Recommendation Report for Prior Notification of Work to Tree(s) in a Conservation Area

REF NO: **AW/355/14/TC**

LOCATION: 4 The Drive
 Aldwick

PROPOSAL: Fell 1 No Red Maple tree with the Craigwell House Conservation Area

← T 2 = RED MAPLE

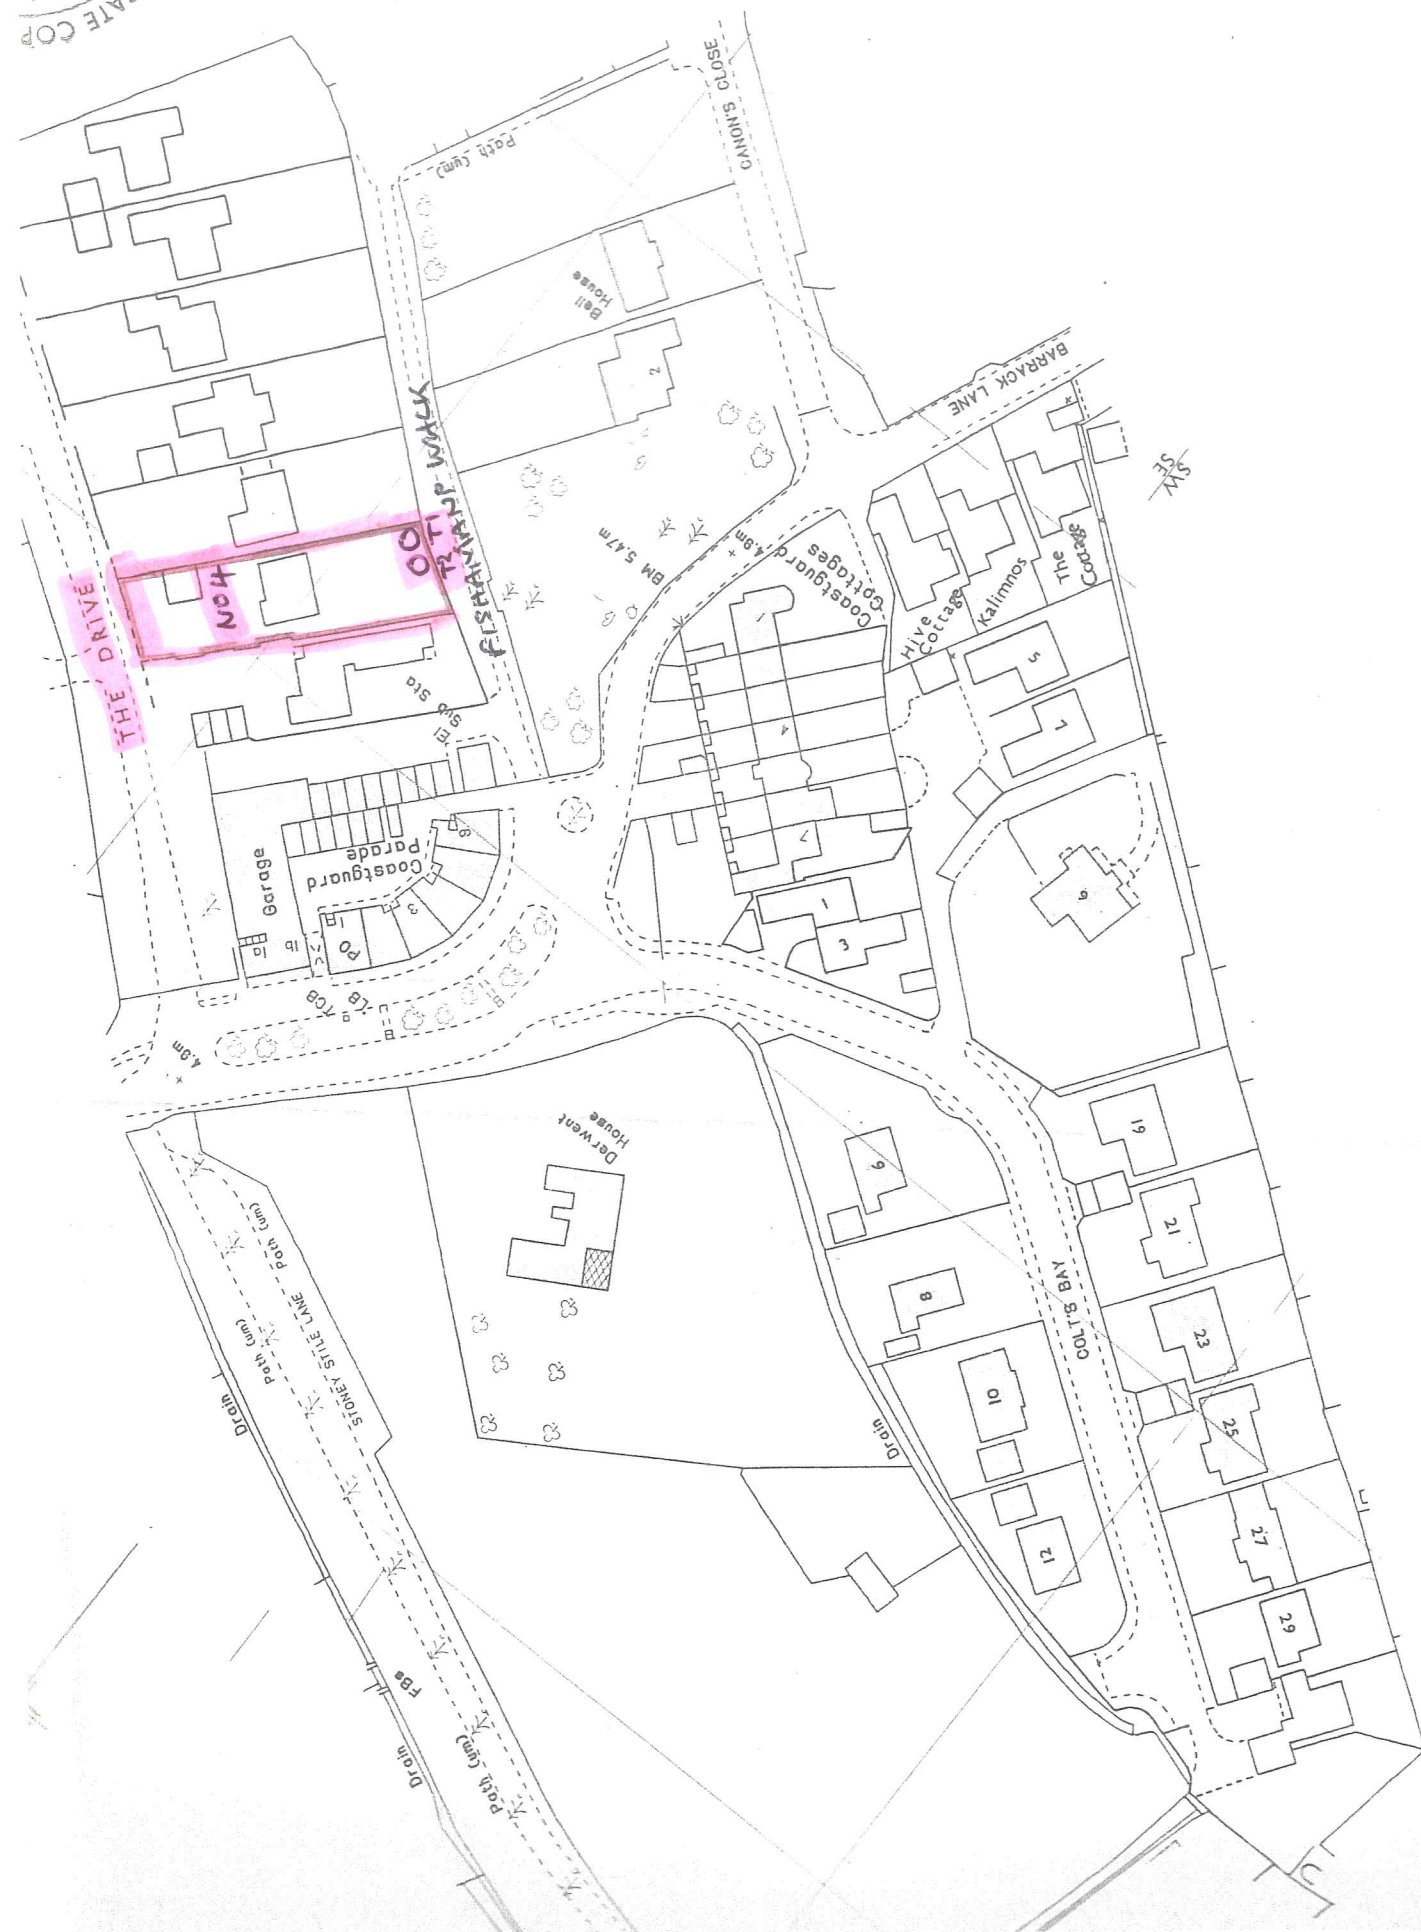
- T2 lies in Aldwick Bay conservation area, which is a high amenity landscape with young, semi mature, mature, and over mature trees specimens present. T1 has no active TPO order.
- T2 is located abutting the rear boundary of 4 the Drive, in the eastern area, west of T1.
- It was clear from the site inspection that T2 is in a very poor condition, and has very poor crown density. Also there is clear evidence of poor pruning techniques (as there is a number of 'pegs' present).
- Speaking to the applicant/owner of T2, it was alleged that this individual did not flush last year. This would suggest this tree is standing dead.
- Given the overall condition of T2, the retention span of the outlined tree is likely to be greatly reduced.

The Red Maple is located in the rear garden of 4 The Drive abutting the rear boundary. The report prepared by the Council's Tree Officer states that the tree the subject of this application "in a very poor condition, and has very poor crown density. Also there is clear evidence of poor pruning techniques (as there is a number of 'pegs' present)."

Given the overall condition of the tree it is identified that its retention span is likely to be greatly reduced. Therefore, it is recommended that no objection is raised in relation to the proposed felling of this tree in accordance with the guidance provided by the Council's Tree Officer.

- For the above reasons, this tree would not be suitable for a TPO order.
- I therefore would have no objection to the proposed operation of felling of T2.
